ConveryPrentyShields

N/24/00252/PP- Planning Validation

Following your letter from the 22.03.2024 please find our response to the points you raised below.

DRAWING Proposed Block Plan

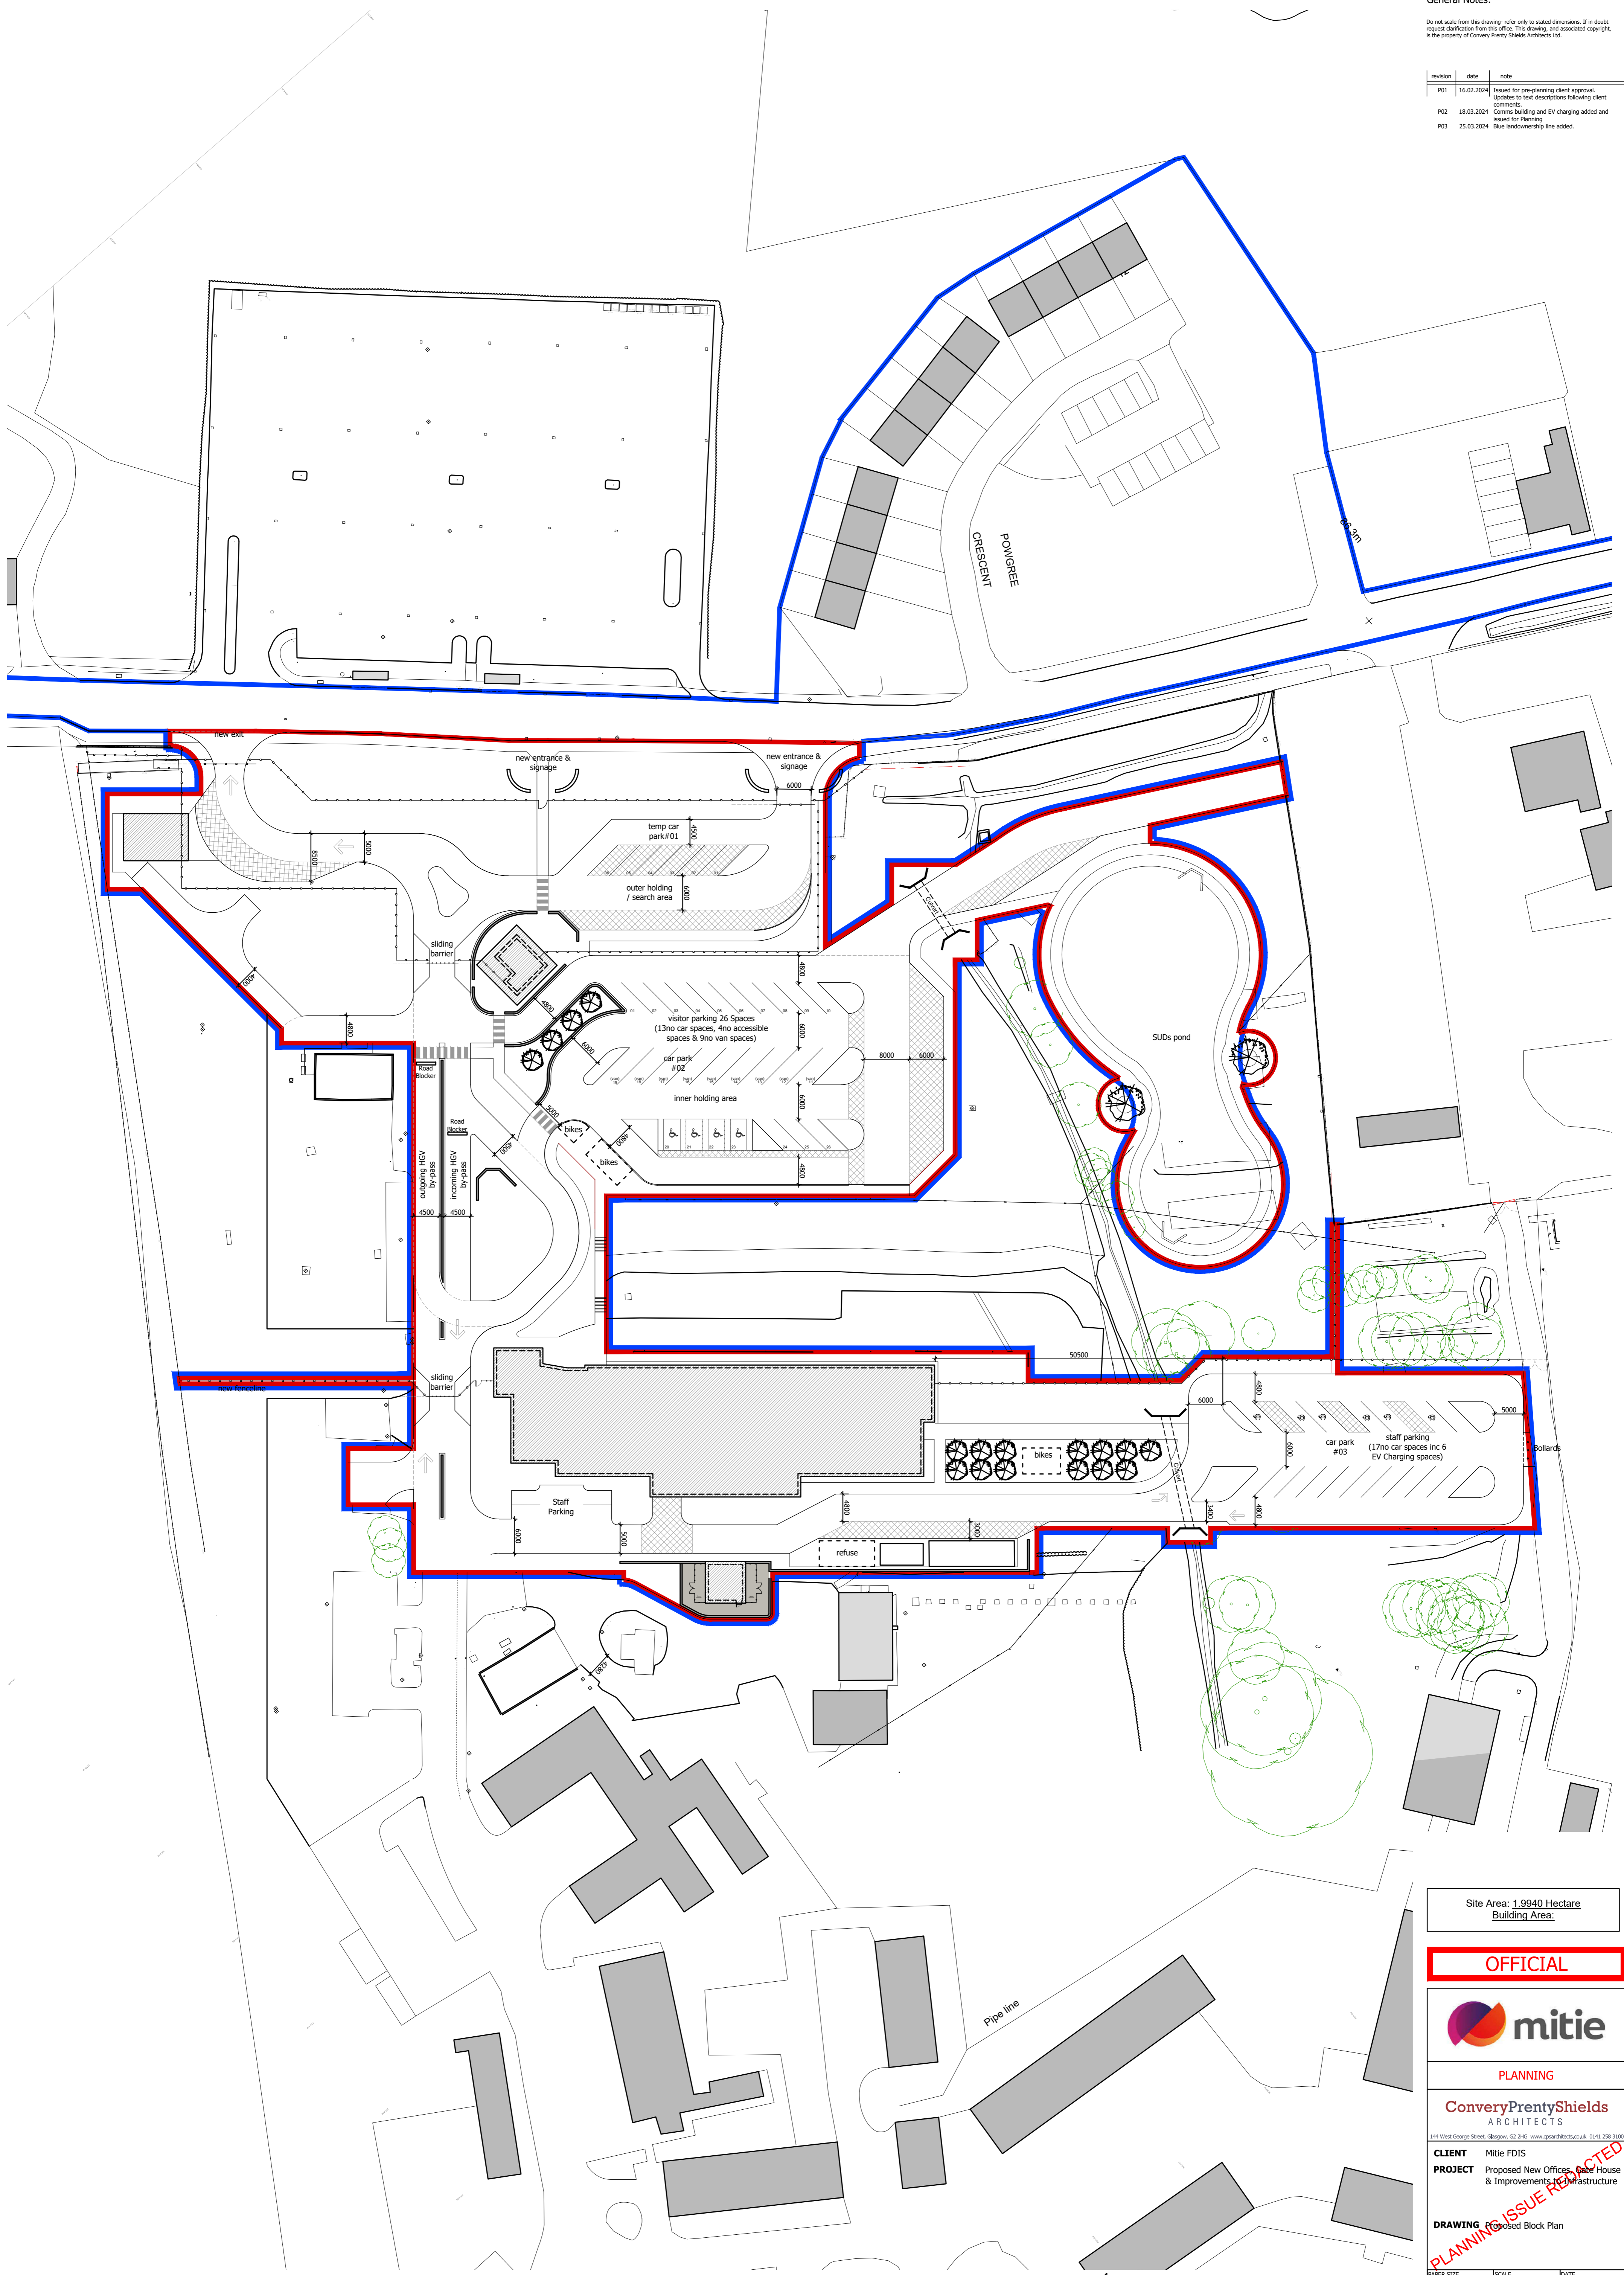
2. Please outline application site in red and any other land in the applicants control in blue on location plans.
Blue line added to location and block plans.

DRAWING NUMBER	REVISION
2281_CPS_P_200	P02

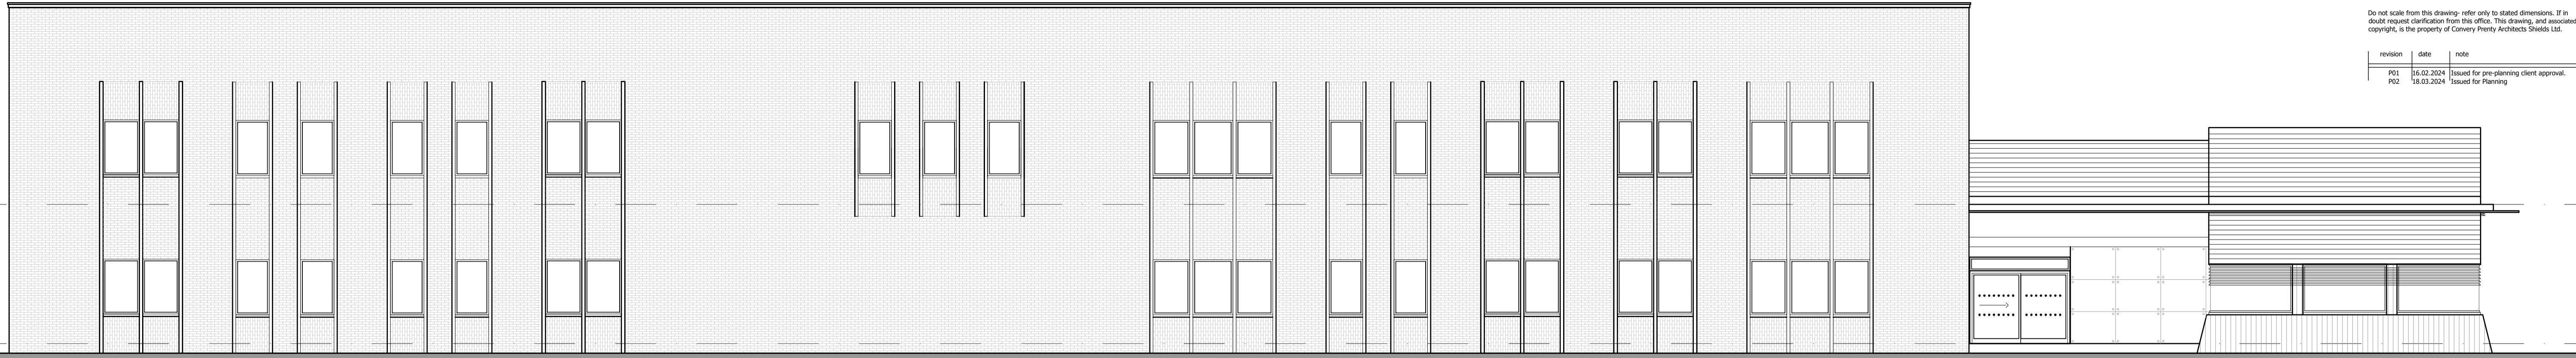
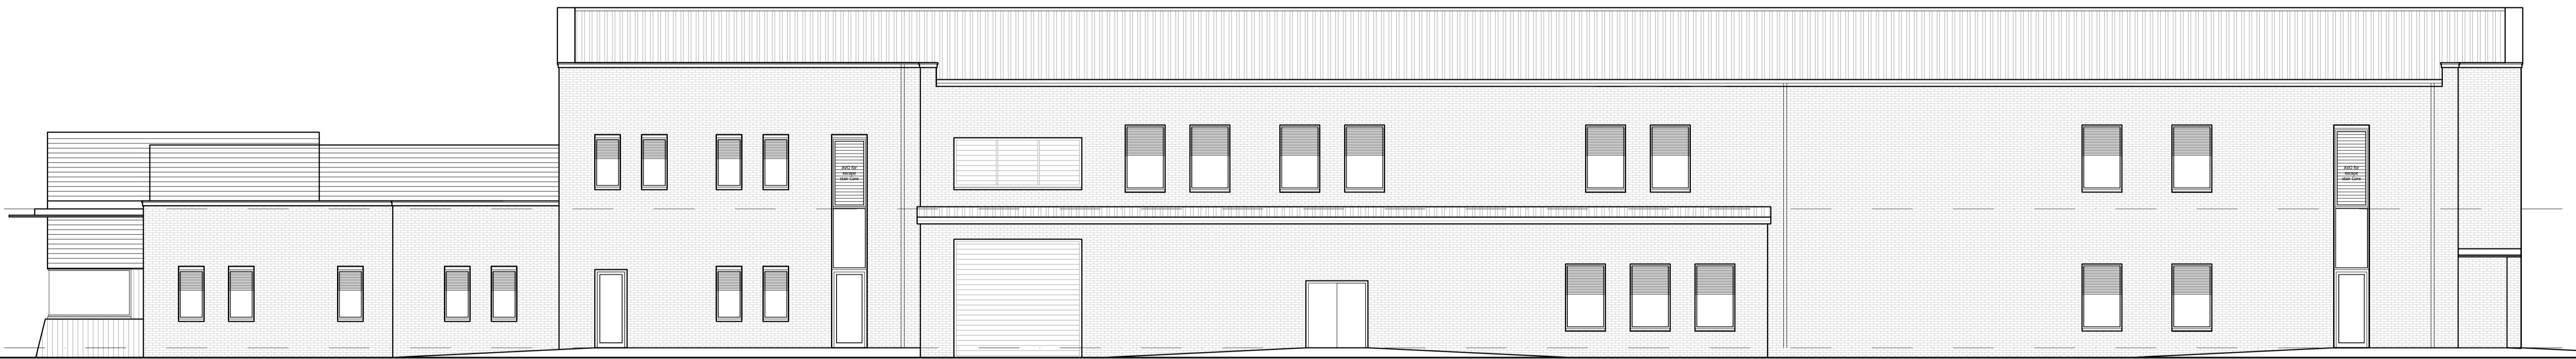
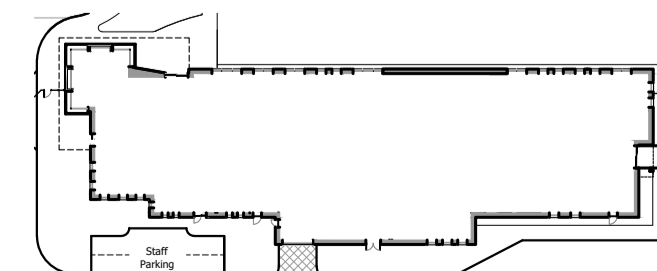
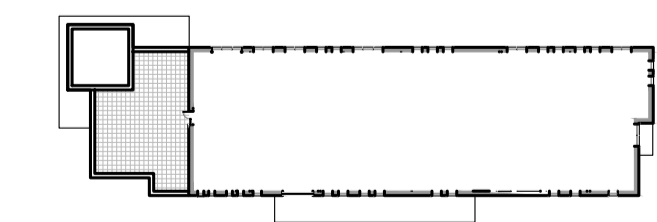
4. Please add position of all windows and check window positions on elevations of drawing number- 2281_CPS_P_200 as it does not correspond with the floor plans.
Proposed floor plans updated to match elevation window positions.
